CLEAR VIEW INDUSTRIAL PARK, FILING 2A

GRADING, STORM AND EROSION CONTROL PLANS

Figure 13-12b. Emergency Spillway Profile at Embankment

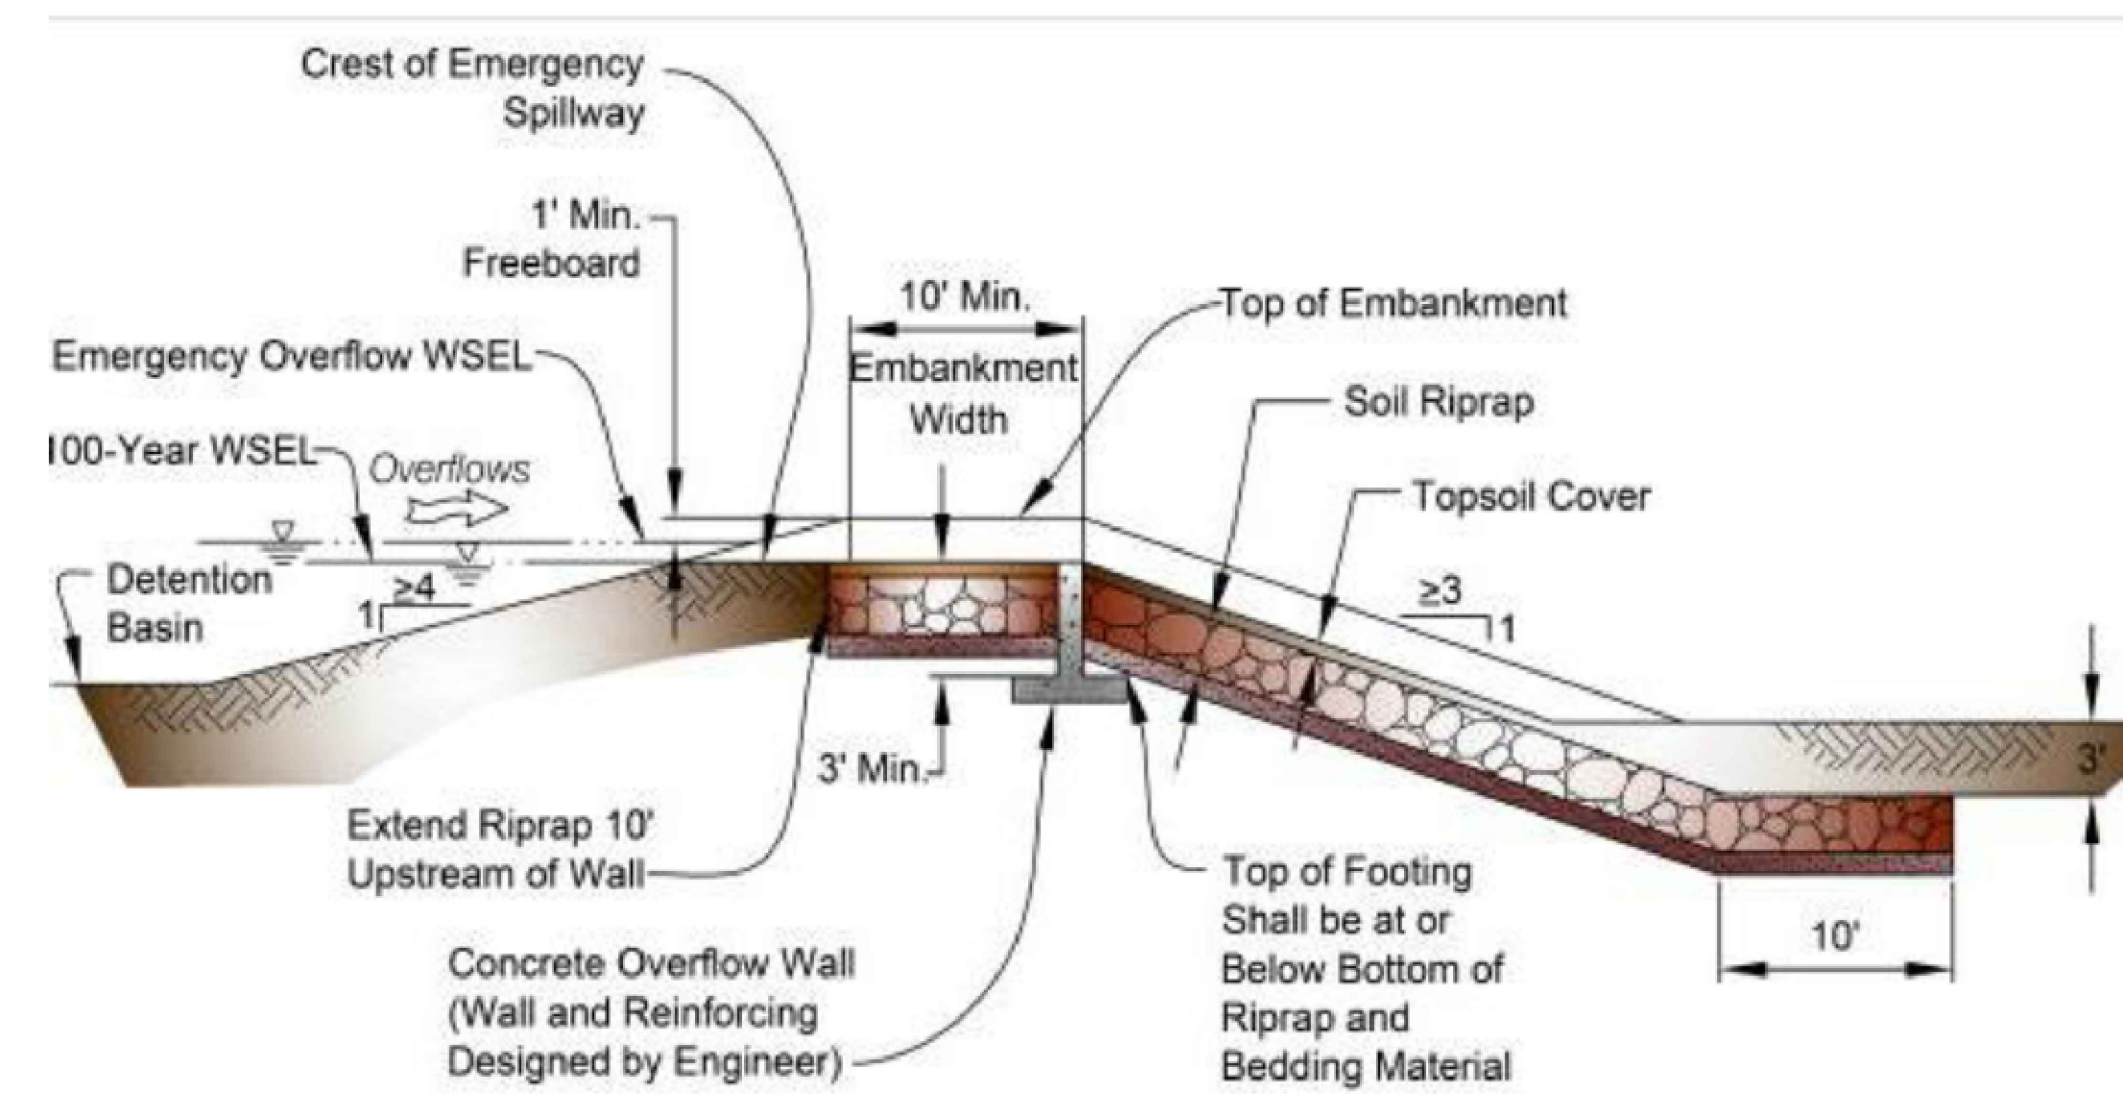
Remove. This appears to be a duplicate

SHEET TITLE: STORM PLAN AND PROFILE

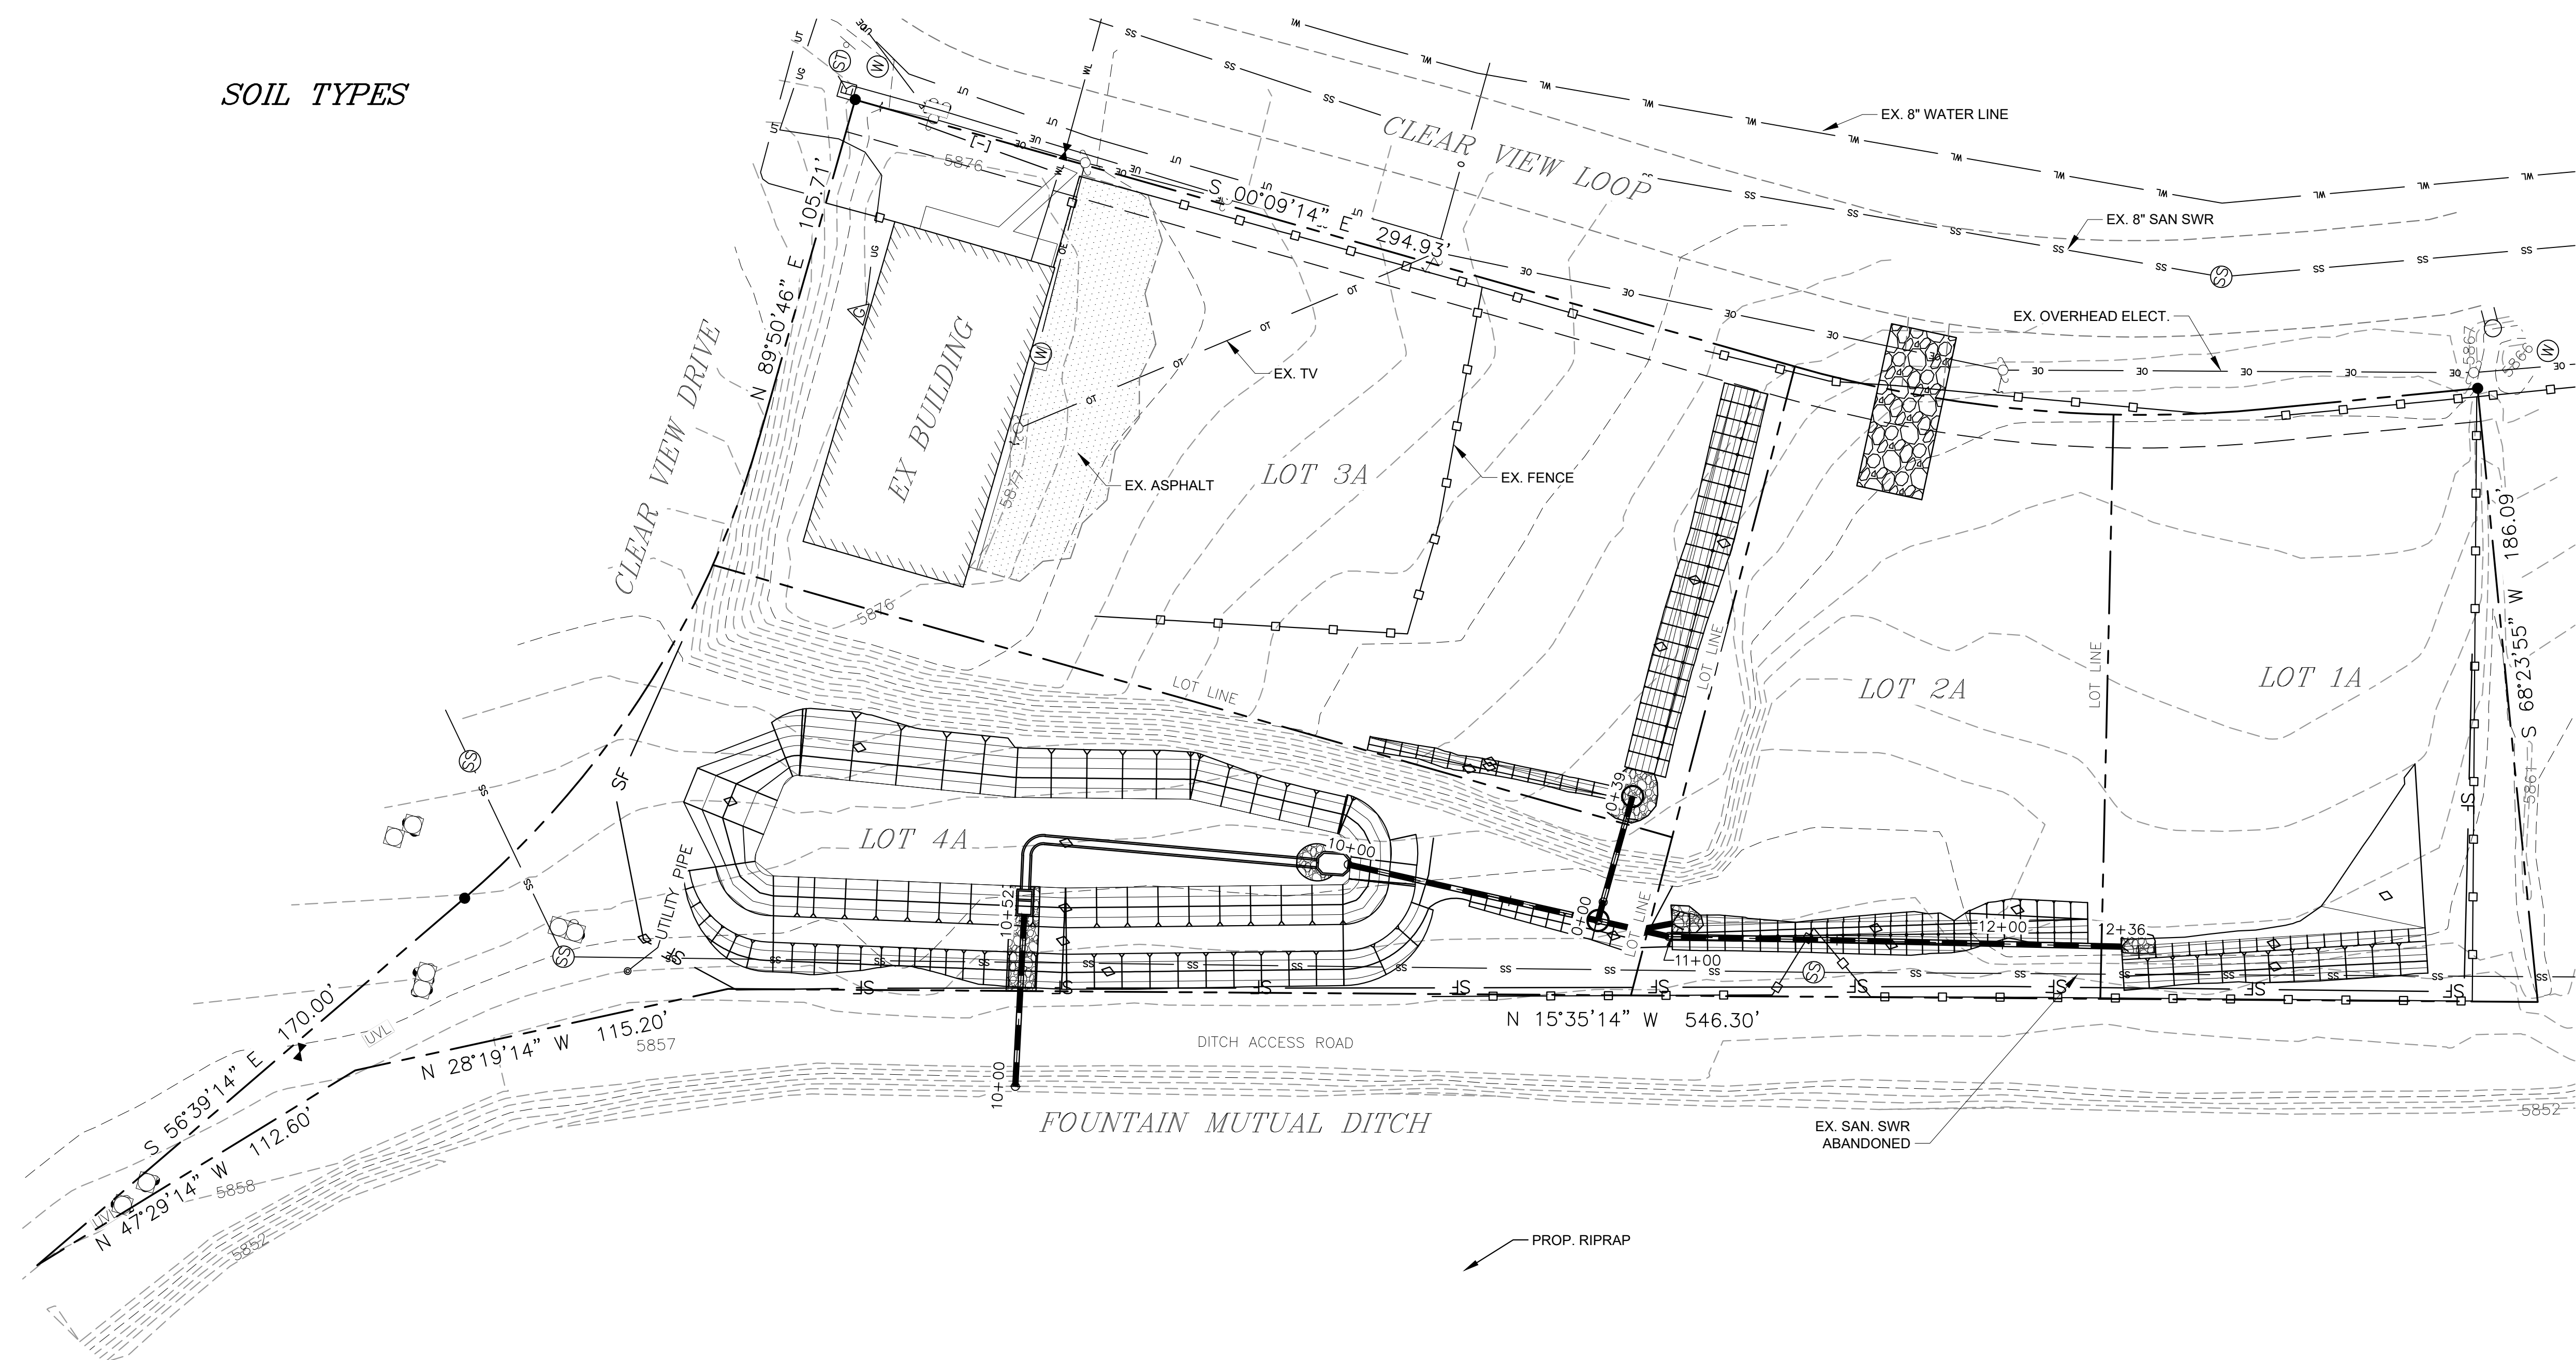
Extent of riprap does not match the spillway detail on sheet 6 which shows riprap extending 10 feet past the toe of the channel and 3 feet below the bottom of channel.
